THREE RIVERS DISTRICT COUNCIL

PRE-APPLICATION ADVICE NOTE

My Ref : 23/1993/PREAPP
Your Ref :
Date : 3 January 2024
Contact : Claire Wilson
Department: Development Management

Application: Pre-application: Substantial demolition of existing dwelling and construction of part single, part two storey front and rear extension, first floor side extension; provision of rear juliet balcony, relocation of entrance door, internal alterations and alterations to fenestration; external materials including brick work.
Address: 4 North Approach, Moor Park, Northwood
Reference: 23/1993/PREAPP

PROPOSED GROUND FLOOR PLAN

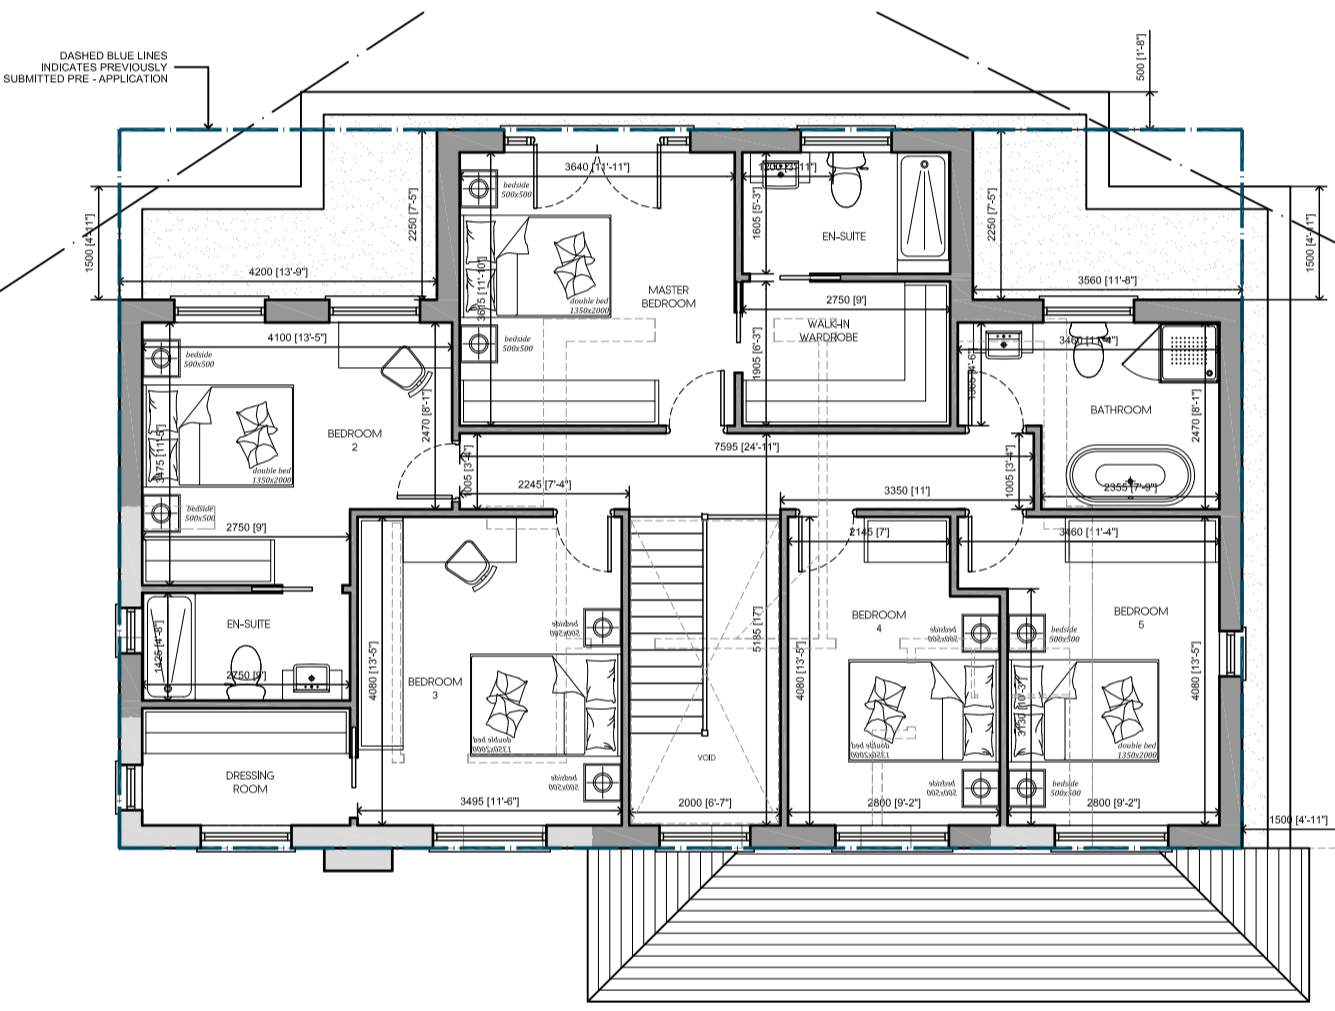
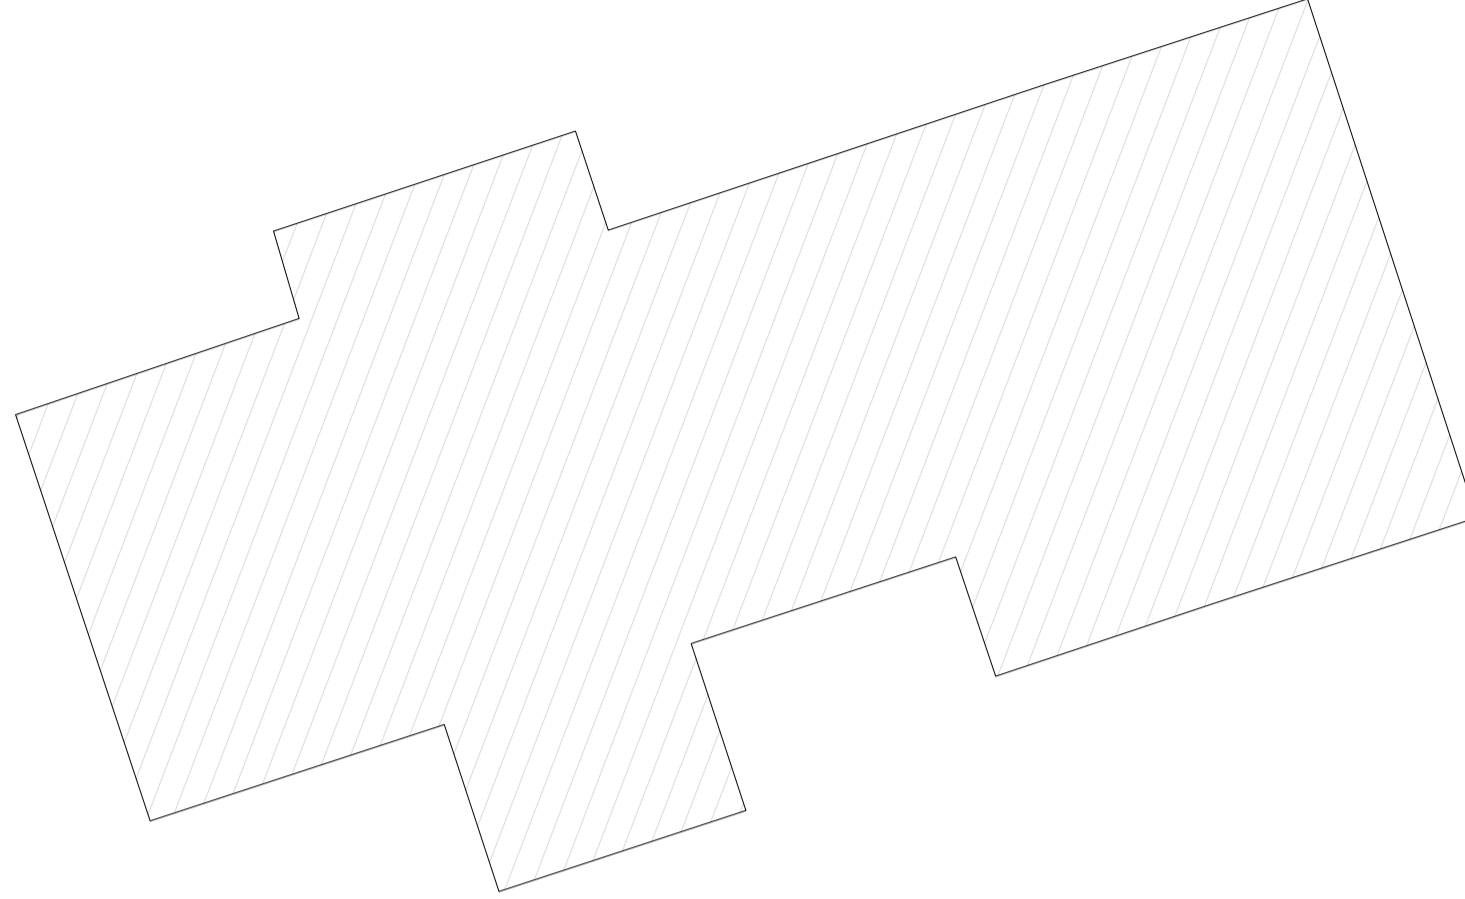
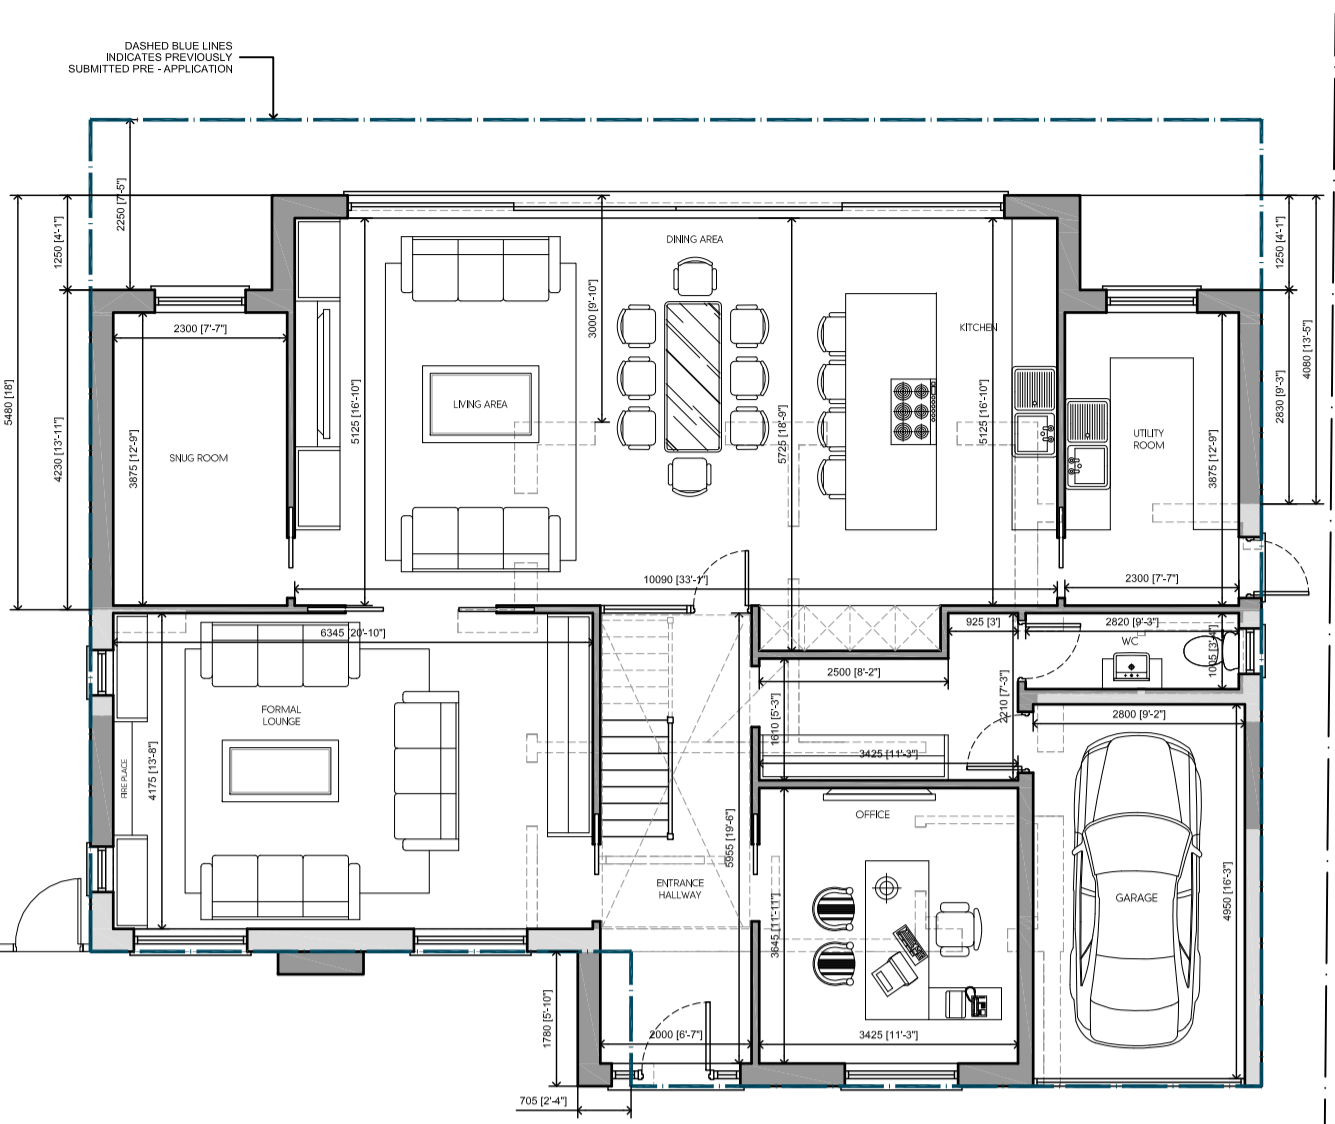
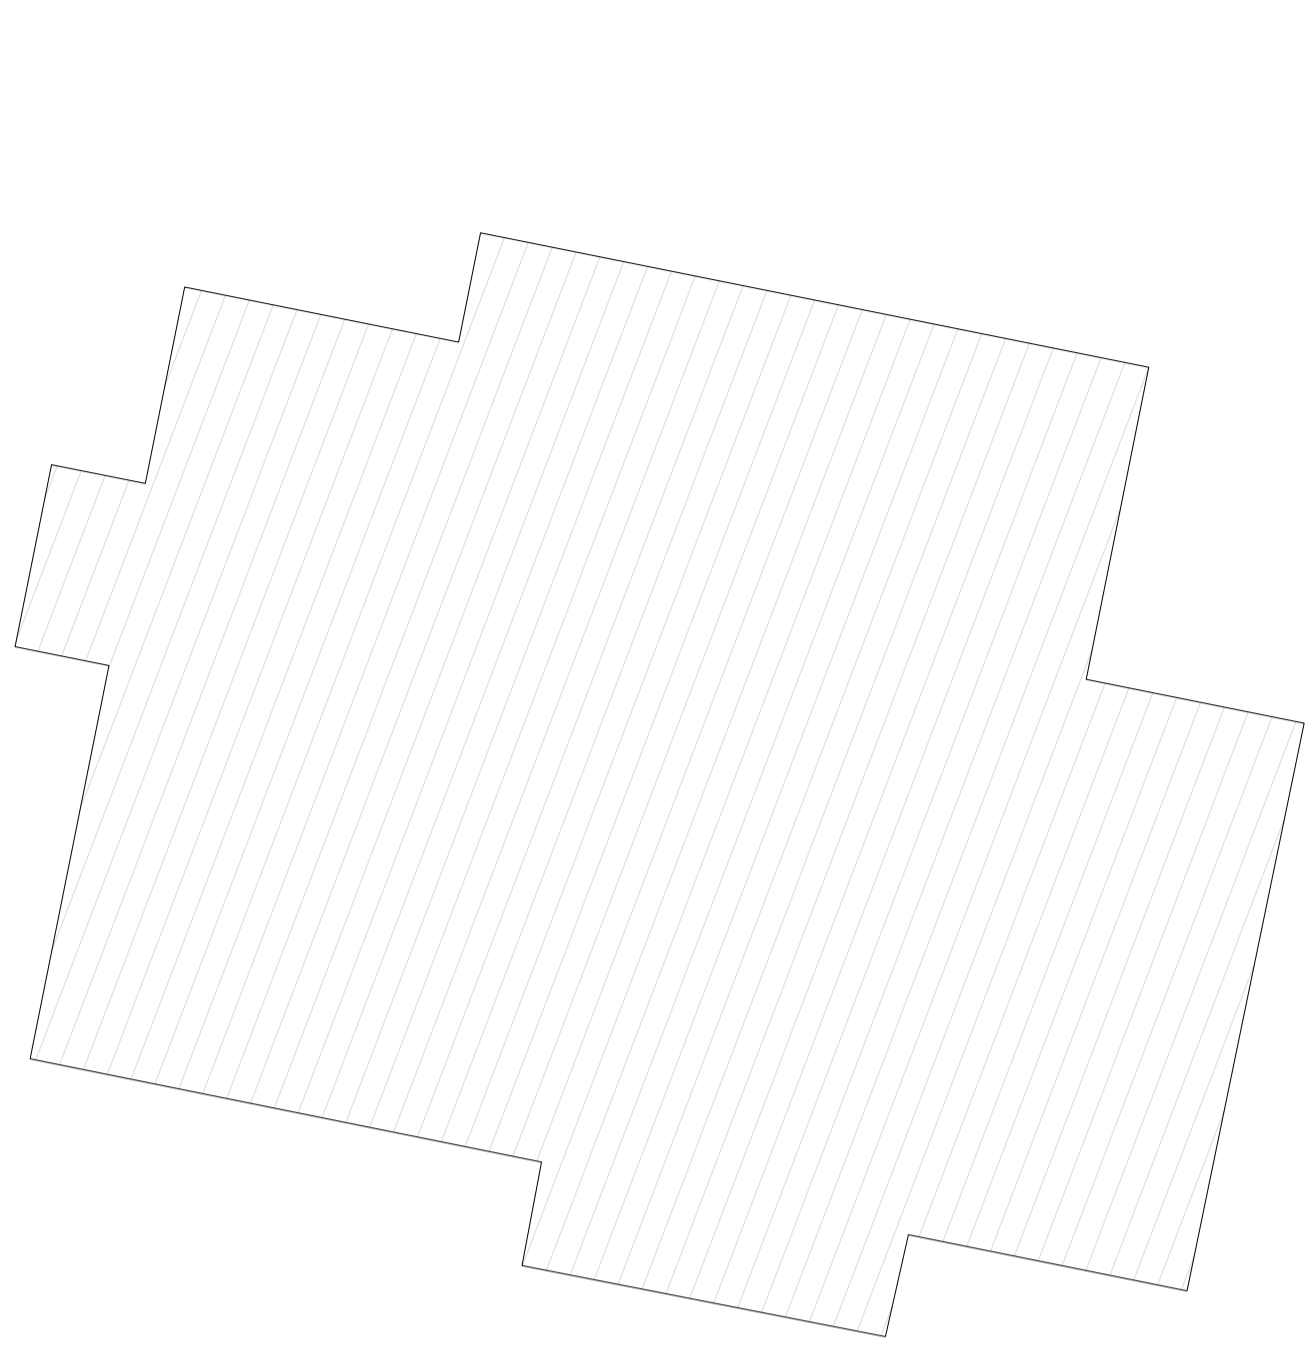
As such, given that the existing dwelling is a largely unaltered example of a pre-1958 dwelling, the Local Planning Authority raises an in-principle objection to the level of demolition proposed. As part of any future planning application, the applicant would be strongly advised to retain more of the original walls and features. At present, an in-principle objection is raised and it is viewed that the proposal is contrary to Policy DM3 of the Development Management Policies LDD and the provisions of the Moor Park Conservation Area Appraisal.

As noted, the plans include substantial demolition of the existing dwelling. As already set out, an in-principle objection is raised and it is therefore advised that any future proposal would need to retain more of the original external and internal walls of the dwelling. Notwithstanding this, an assessment has been made of the proposed development as currently indicated.

In this case, the plans indicate a distance of 1.5m would be retained at first floor level which would be in accordance with the guidance set out in the Conservation Area Appraisal. With regard to plot frontage width, the plans indicate that there would be no increase in width at ground floor level and a plot coverage of 77% would be retained. Thus, there is no in principle objection to the provision of a first floor side extension in this regard.

The plans indicate that the proposals would result in a plot coverage of 16.7% which is further indicative that the scale of the extensions should be reduced.

The submitted plans indicate that the 45 degree splay line has been taken from a first floor rear window at no.2 and thus not in line with the boundary as set out in Appendix 2. Notwithstanding this, the plans still indicate a 45 degree line would be intruded from the first floor window and given that the neighbour is located at a lower land level and with their rear elevation angled towards the host

dwelling, significant concern is raised that the extensions would be visually overbearing and intrusive to this neighbour. It is suggested that to minimise the impact, the first floor side extension should not extend beyond the first floor rear wall of the dwelling. With regard to no.6, the plans also indicate a 45 degree line intrusion from no.6. Again the 45 degree line has not been taken from the boundary which is further indicative of the excessive scale of the extensions. It is therefore suggested that the scale of the two storey rear extension should therefore be reduced. The plans also indicate a Juliet Balcony at first floor level. Given this would be sited centrally, it is not viewed that it would result in increased harm in terms of overlooking relative to the existing situation as a result of first floor windows.

With regard to the single storey rear extension, Appendix 2 of the Development Management Policies LDD suggests that a maximum depth of 4m would generally be acceptable. The plans indicate that this element would have a maximum depth of approximately of 6.4m from the recessed building line, and a minimum depth of 4m adjacent to no.2. Given the relationship with both neighbouring dwellings, it is suggested that some reduction would be appropriate in order to ensure that the extension would not be unduly overbearing.

PROPOSED FRONT ELEVATION

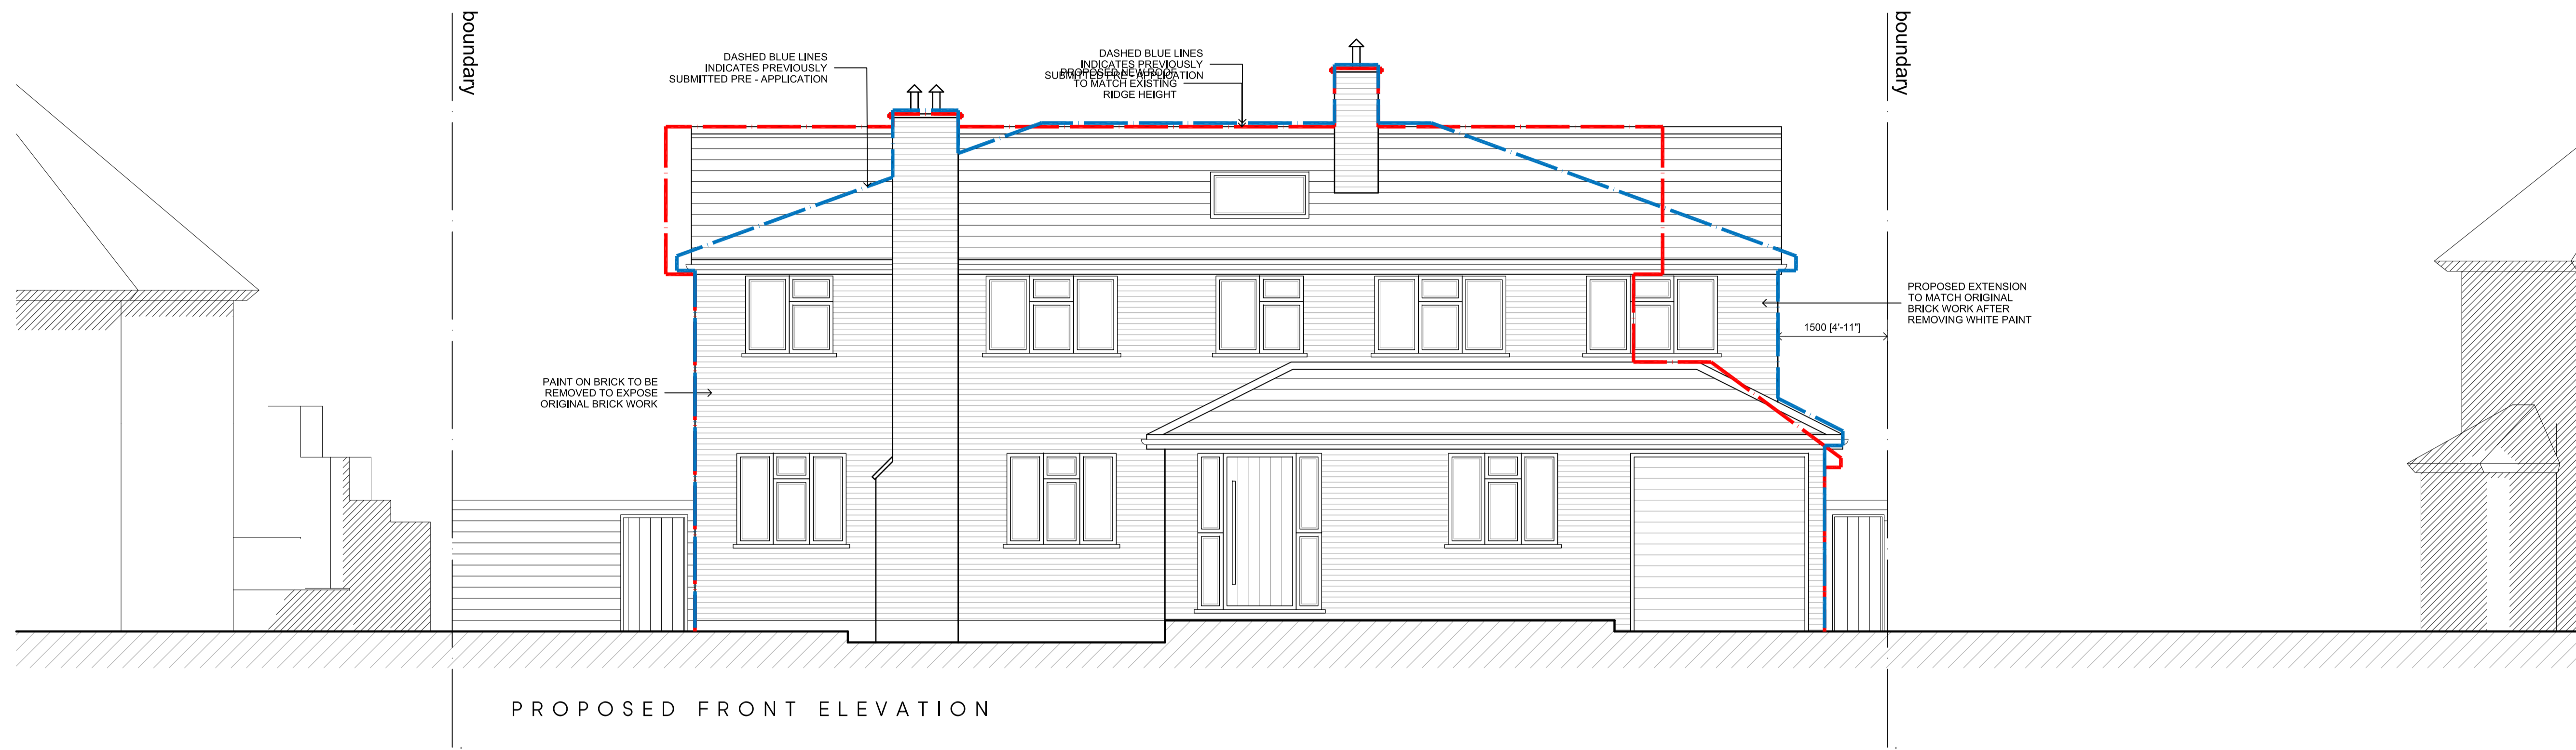
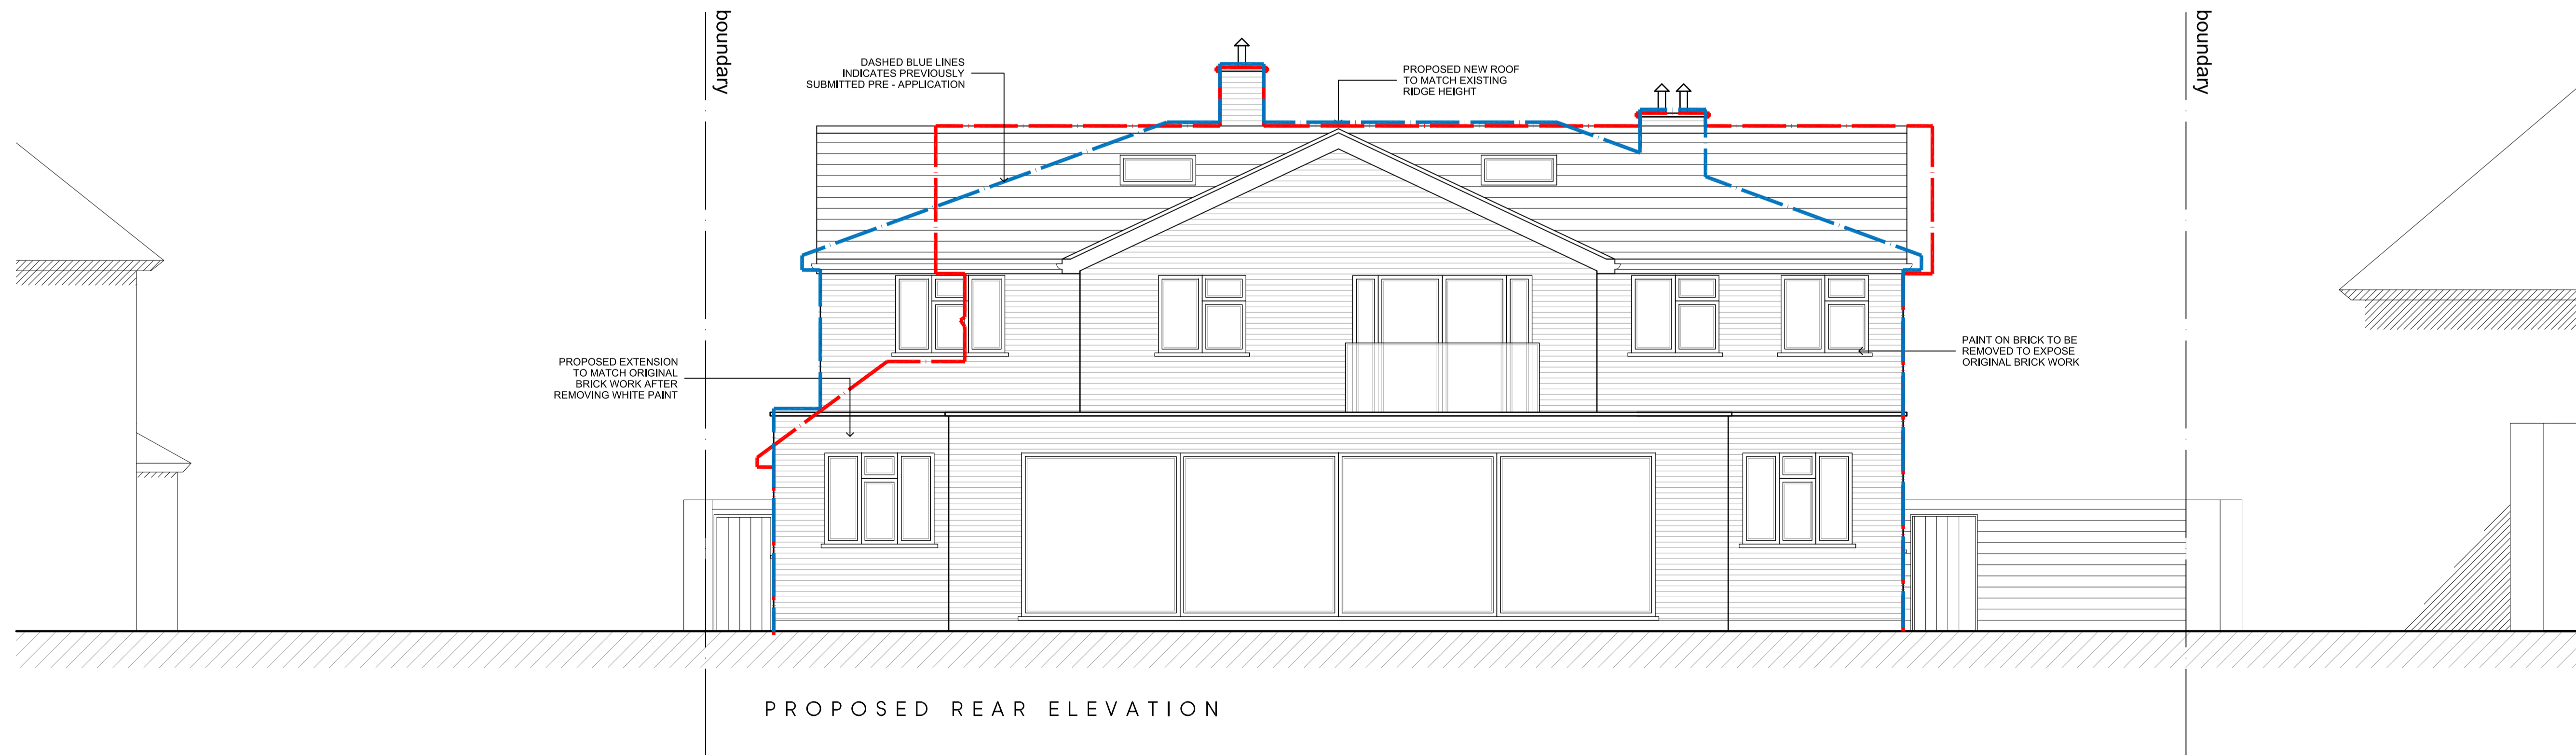
The roof form would be wholly removed, and a new hipped roof form is proposed. Concerns are raised that in conjunction with the 'boxy' form proposed, that the new hipped roof form would fail to enhance the character and appearance of the existing dwelling. The gabled roof form appears to be original to the dwelling and is sympathetic to its architectural style. It is therefore encouraged that the gabled roof form is retained going forward.

To the front elevation, the plans include the infilling of the front canopy adjacent to the garage. Whilst it is acknowledged that the design of the original canopy has been altered due to the addition of a pitched roof form, the general form has been retained. The canopy adds some interest to the front elevation and contributes positively. As such, the loss of the feature would be regrettable, and it is encouraged that this is retained going forward. The plans also indicate alterations to the fenestration detail. At present, the existing fenestration detail sits to one side of the host dwelling resulting in a somewhat asymmetrical appearance of the host dwelling. This is an original part of the design of the dwelling and concerns are therefore raised that the addition of further windows would result in loss of the original detailing of the host dwelling.

The plans have also been annotated to include the removal of paint and the reinstatement of brickwork. Brickwork is acknowledged to be a sympathetic external material and it is unlikely that an objection would be raised to this. However, it is encouraged that full details with digital samples should be submitted with a future application.
